2<sup>nd</sup> June 2021

**WYKHAM PARK FARM**

**Approval of Reserved Matters: Spine Road, including landscaping and associated infrastructure (20/3702/REM).**

TITLE
DRAINAGE LAYOUT
SHEET 2 OF 5

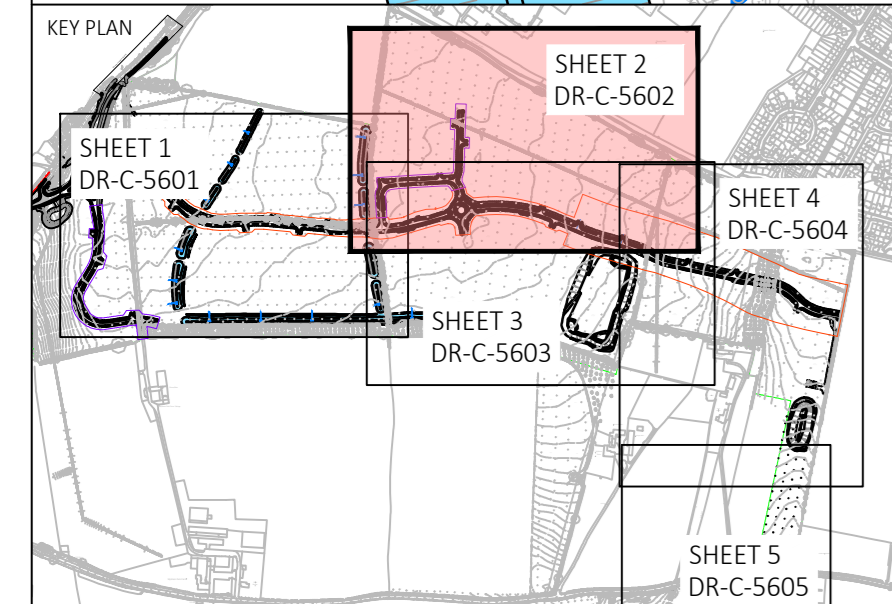
Finally, some queries were raised by the County Councils Drainage team, which required clarification. This clarification has been provided through a **formal technical drainage response note**, prepared by Hydrock. This was confirmed informally with the LLFA as being an acceptable approach to deal with the comments raised.
